Harnett County
420 McKinney Pkwy

SUBJECT: SFD2508-0087
SINGLE FAMILY DWELLING

Here are the results of all Inspections located at **105 POWELL FARM RD**:

S-3
ROOF FRAMING
PLAN

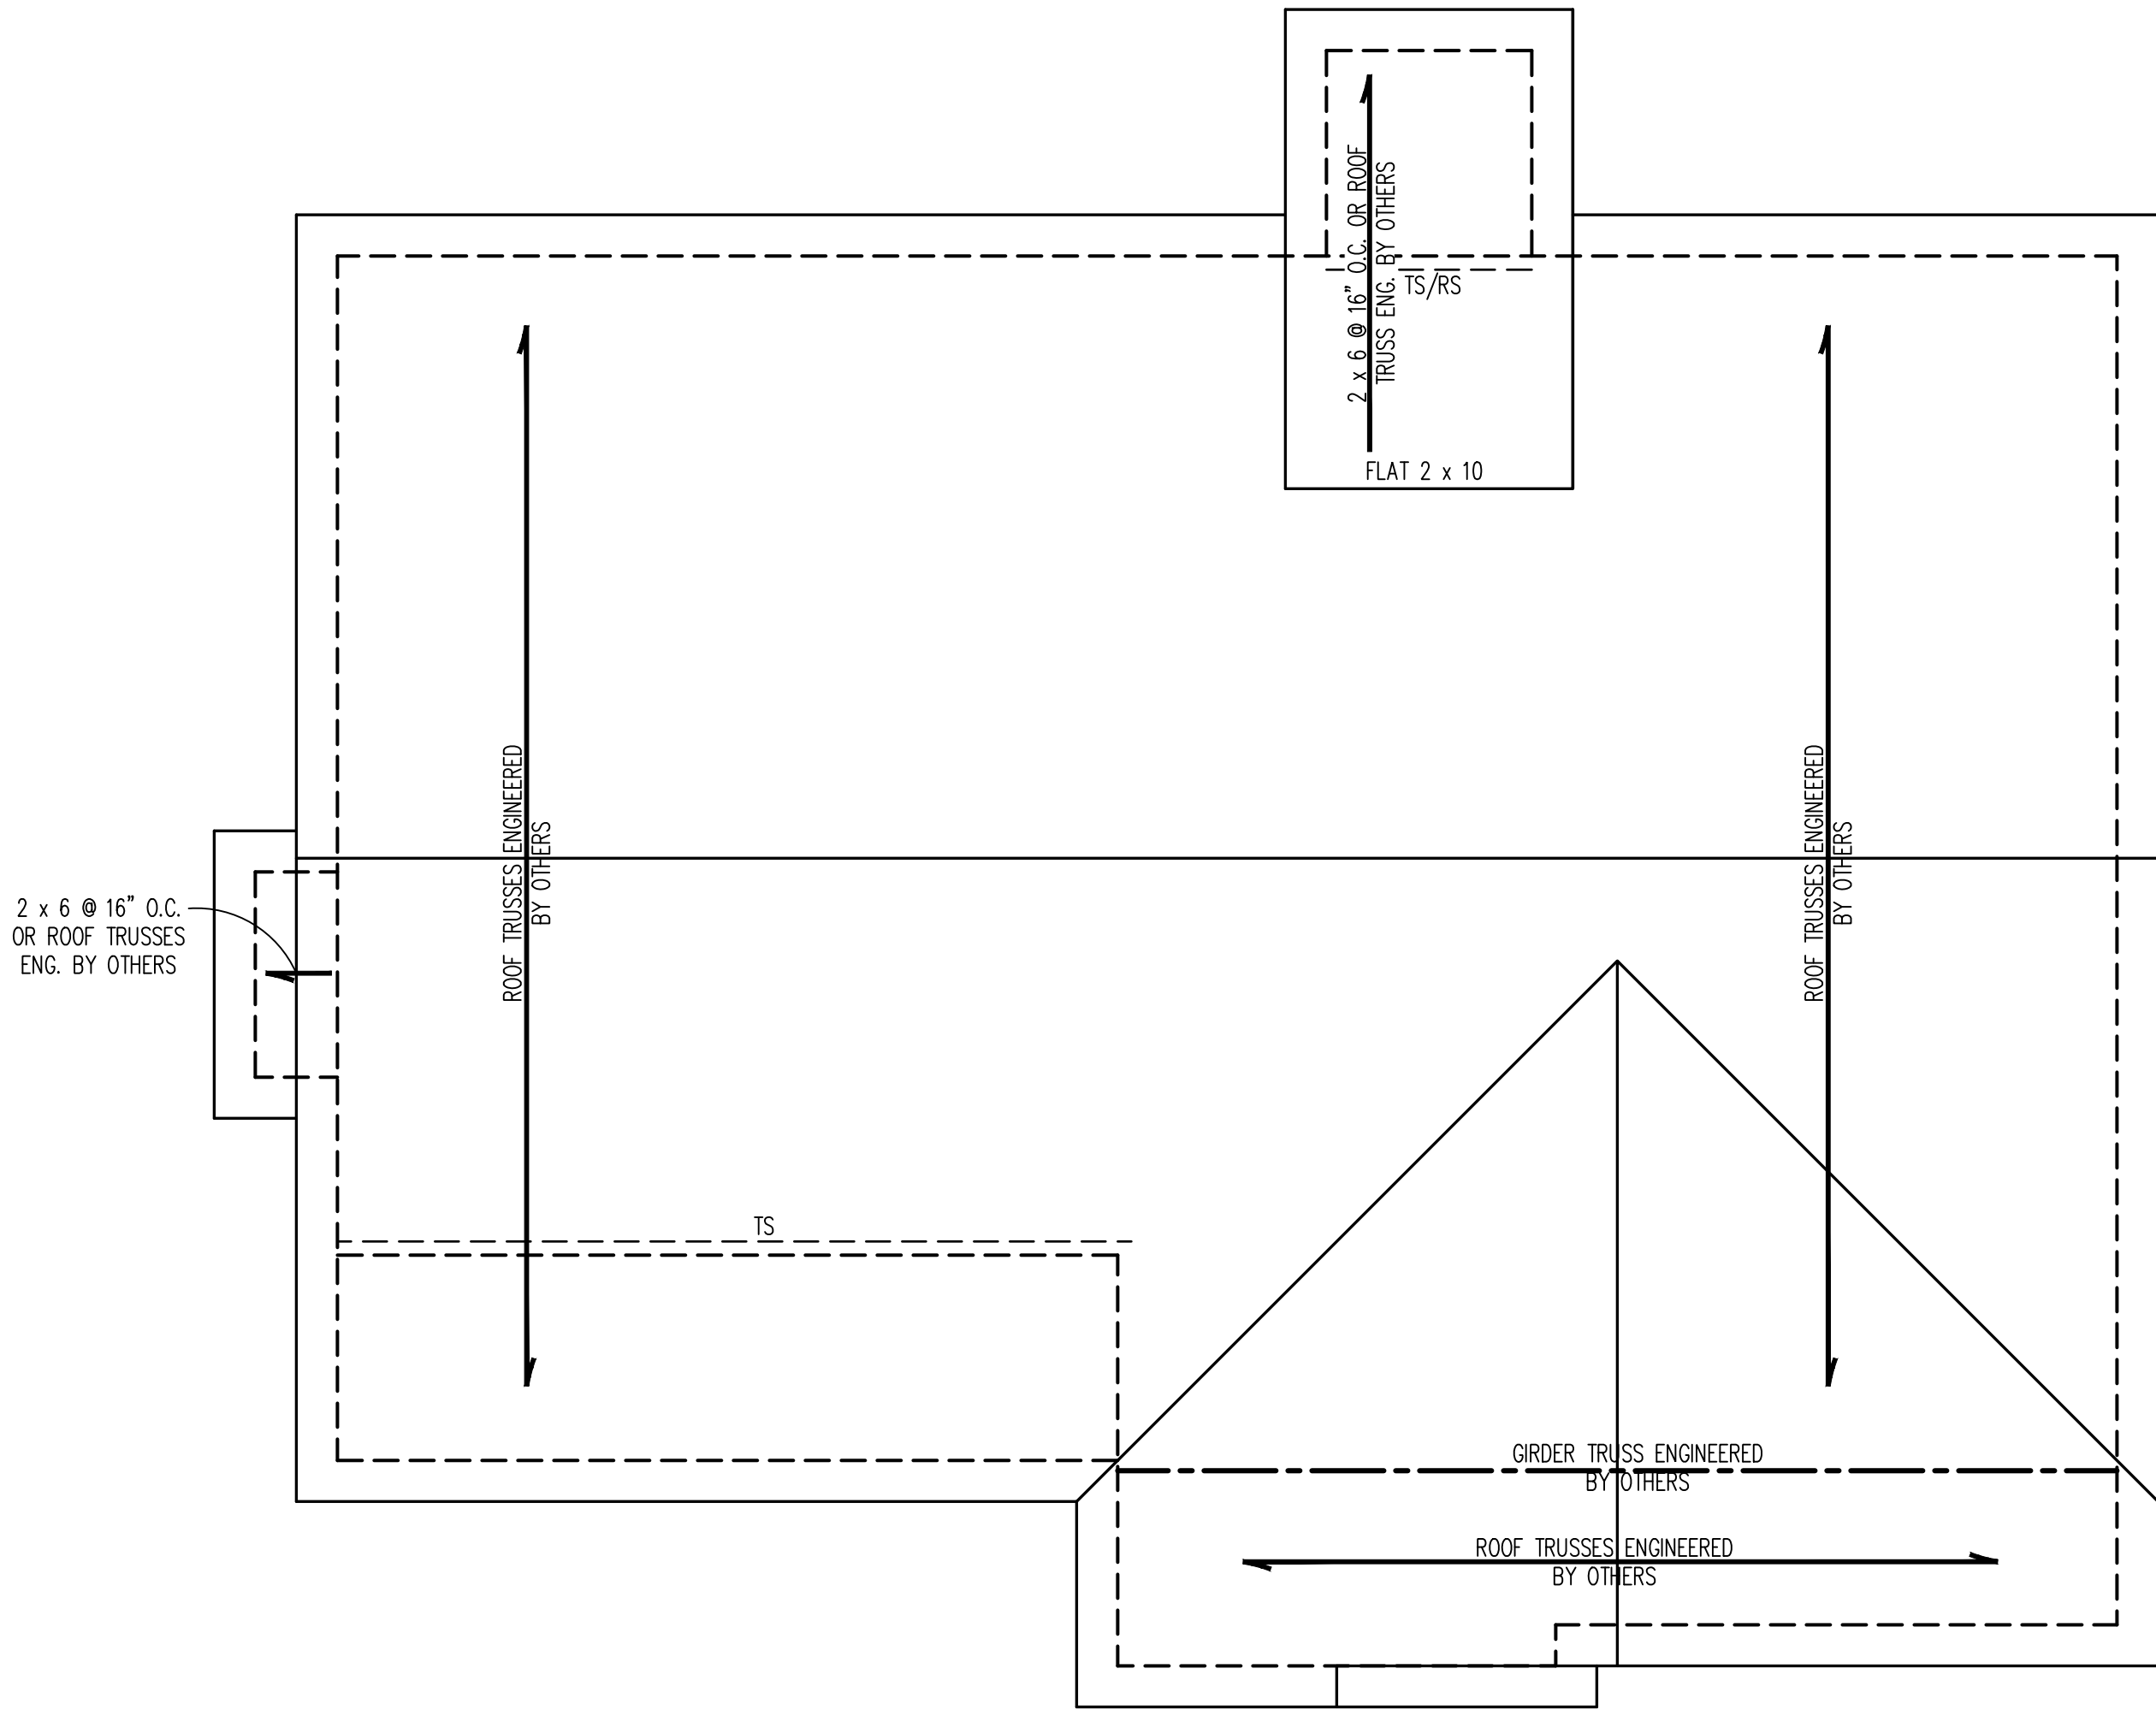
Notes: Need to see a water heater lines to the outside. Need correct nails in girder truss Missing baffles were needed A03 trusses are in the wrong spot Note that the porch posts not installed
